From: Zoe Toppin <Zoe.Toppin@arun.gov.uk>
Sent: 04 May 2021 10:43
To: Planning.Responses <Planning.Responses@arun.gov.uk>
Subject: FW: EP/16/21/PL

Drawing Number: 1241.01.h

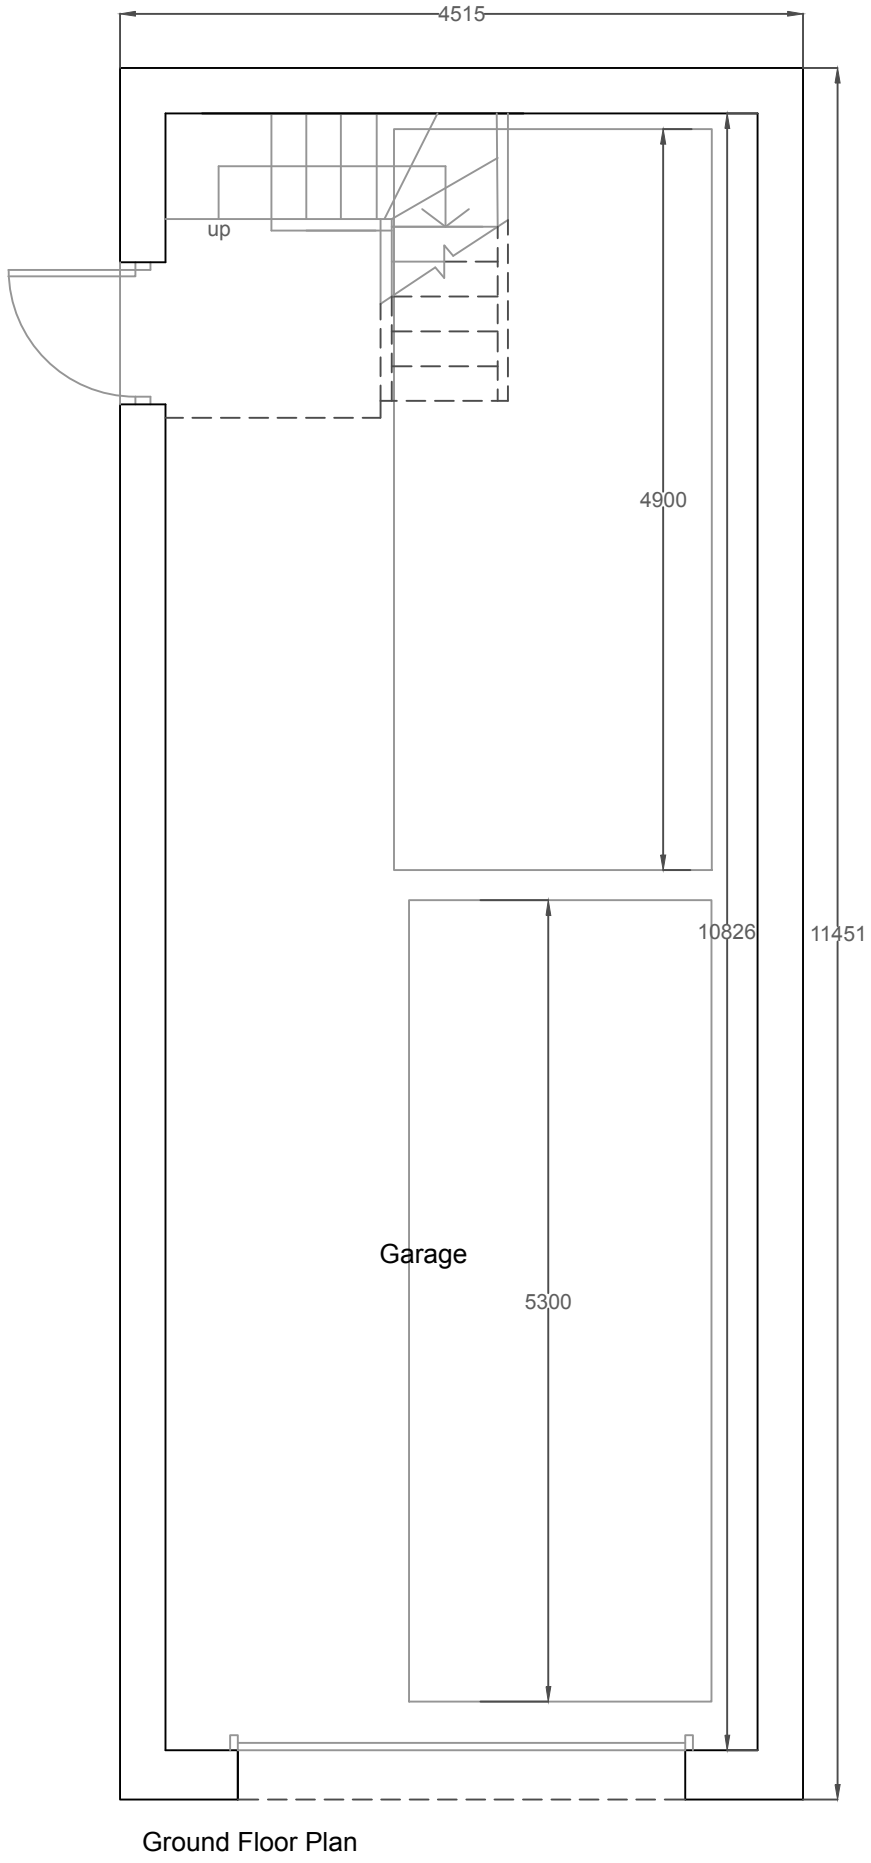
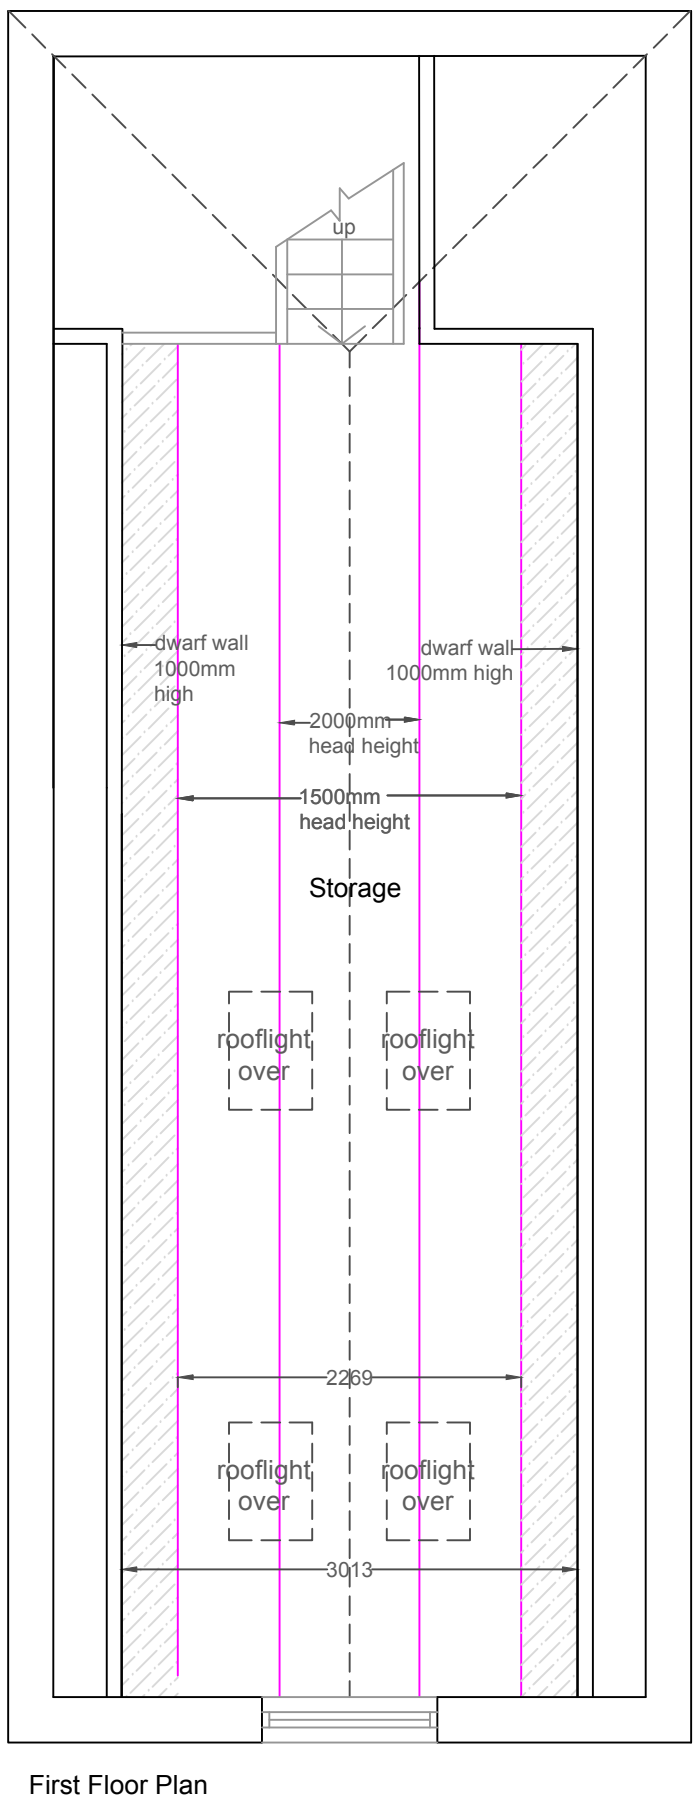
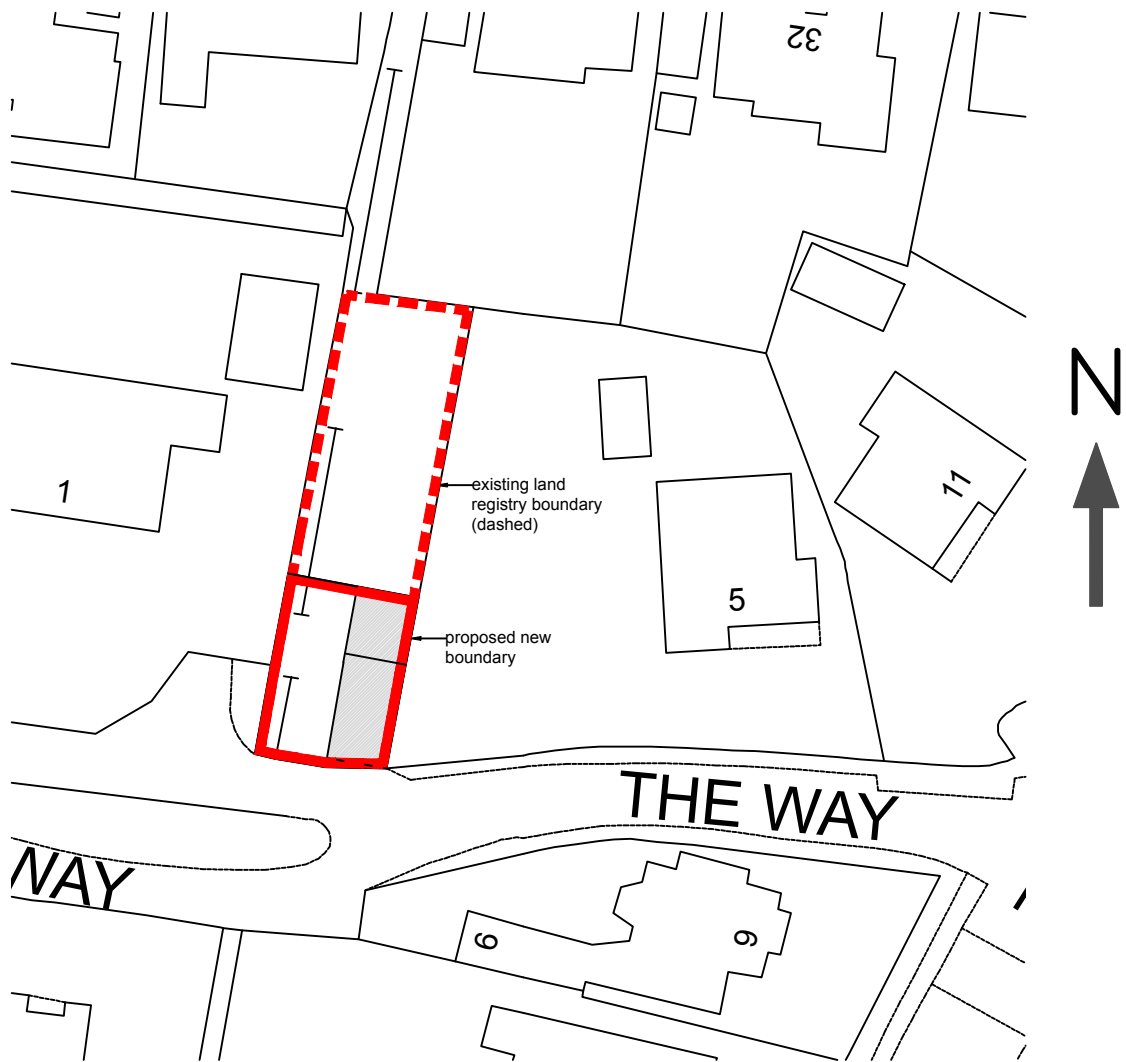
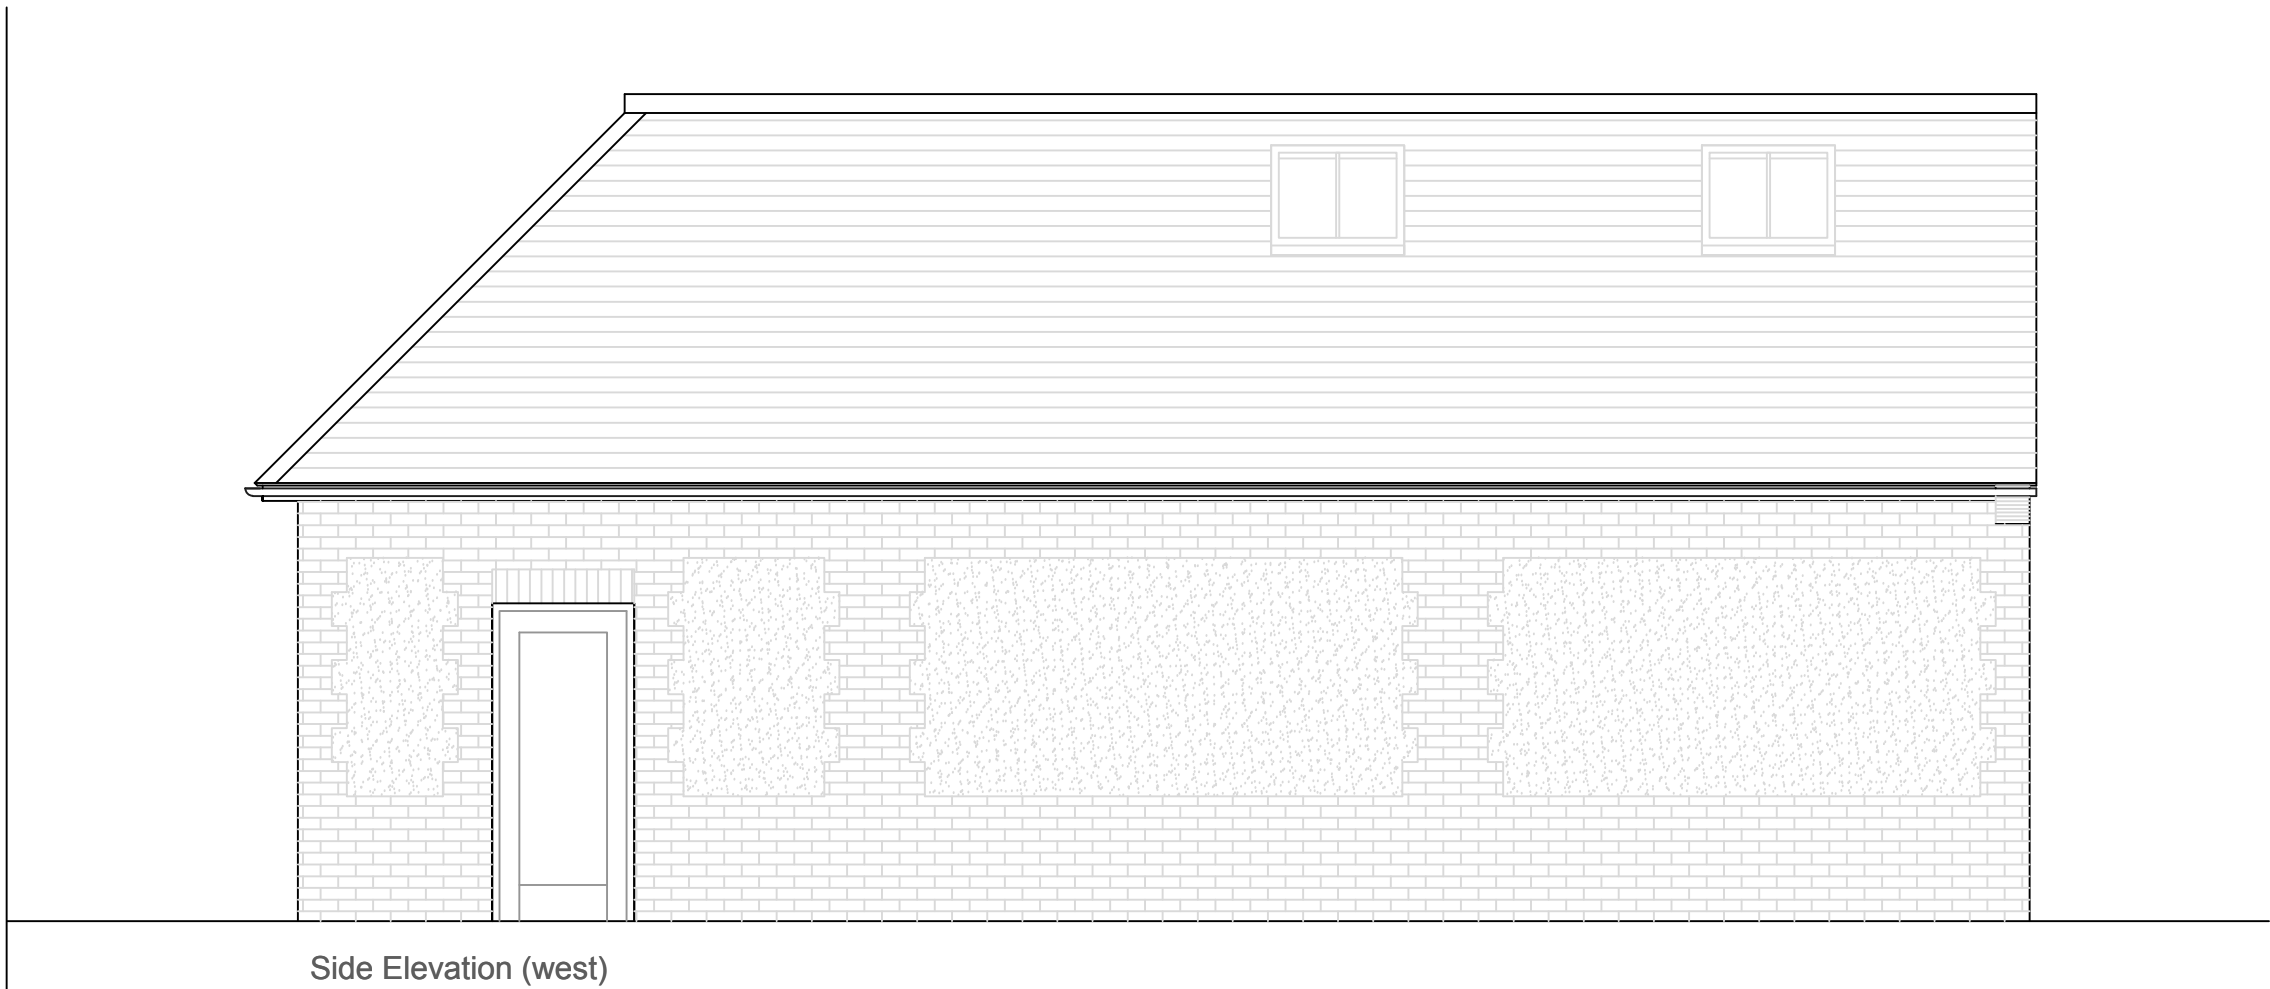
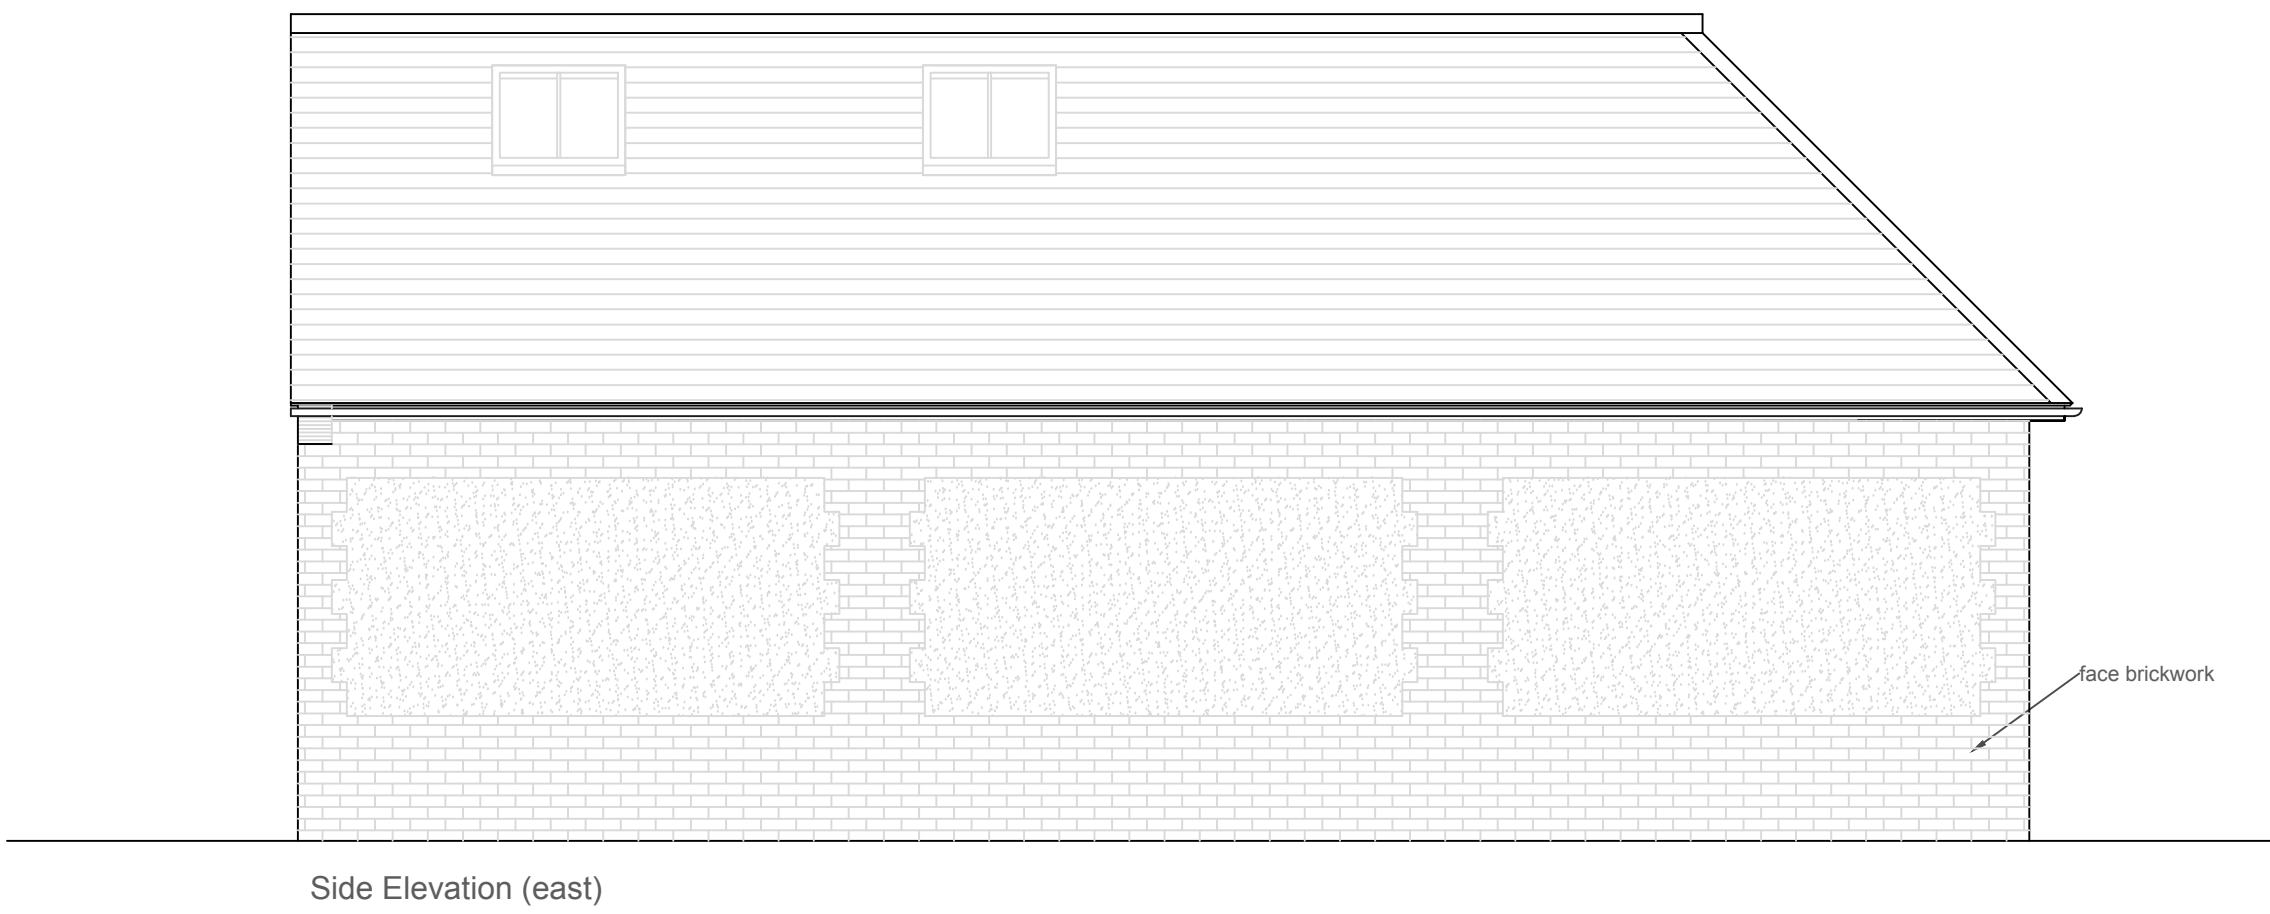
There has been a condition added to this application to show the three windows on the side (east) elevation of the garage will be permanently obscurely glazed and fixed shut up to a height of 1.7m from the finished floor level in order to protect the private amenity to the neighbours at the east. Please can you provide a plan to show this with a cross section from the ground to 1.7m to show the windows will be obscurely glazed and fixed shut up to a height of 1.7m.

There has also been concerns of why a dormer would be necessary for a garage if it is to be used as storage. As a result, it would be necessary to remove the dormer to the garage for this proposal. Please provide amended plans to show the dormer has been removed.

The three windows on west elevation should also be removed from the proposal as the garage will be used for storage there is no necessary need for windows, this will also create amenity issues.

1. An amended plan for the east elevation to show the cross section from the ground to 1.7m to show the windows will be obscurely glazed and fixed shut up to a height of 1.7m.
2. An amended plan to show the dormer has been removed.
3. An amended plan for the west elevation to show the three windows to be removed from the proposal

I have removed the dormer and reduced the number of roof lights. I have also reduced the size of the roof lights and positioned them so the cill of the roof lights are 1.7m from finished floor level so there is no overlooking. I have included a section to demonstrate the position of the roof lights.

I have reverted to a hipped roof at the rear of the building which is as per the pre-application advice scheme. I have done this in order to accommodate the staircase and still provide space for the two cars in the garage.
